CM/6/20/PL

North Barn Climping Street Climping BN17 5RG

Change of use of agricultural barn to 1 No dwelling. This application may affect the setting of a listed building.

PROPOSED SOUTH ELEVATION

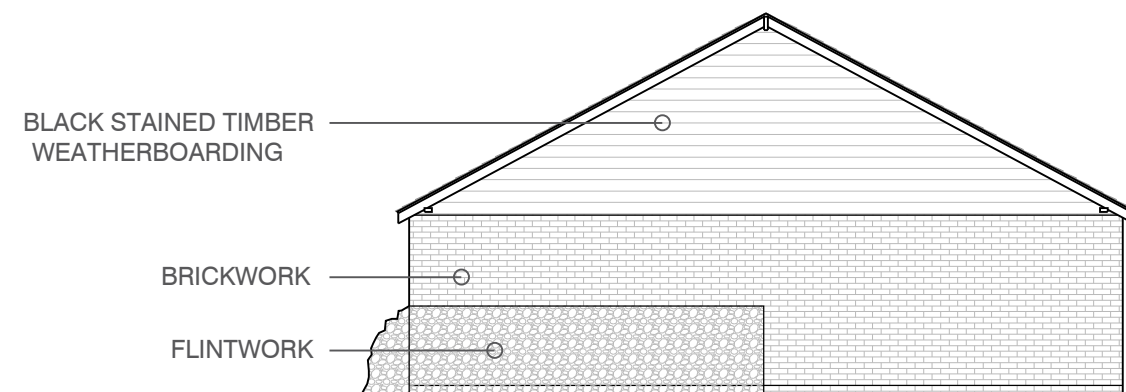
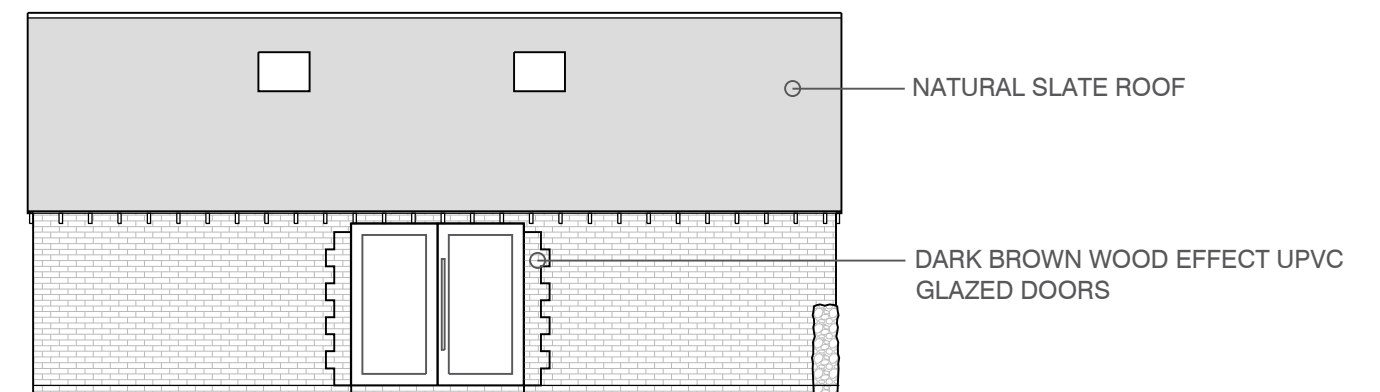
The proposal involves a number of alterations, the majority of which are internal. These do not appear to harm the character of the building and seem to be acceptable. From a conservation perspective it is disappointing to see that upvc windows are proposed. It is suggested that in order to the proposal to have the greatest impact the windows and doors should be of wooden construction. If minded to approve the application you could condition details of the windows and doors to be submitted so as to ensure that they have a positive impact upon the building.
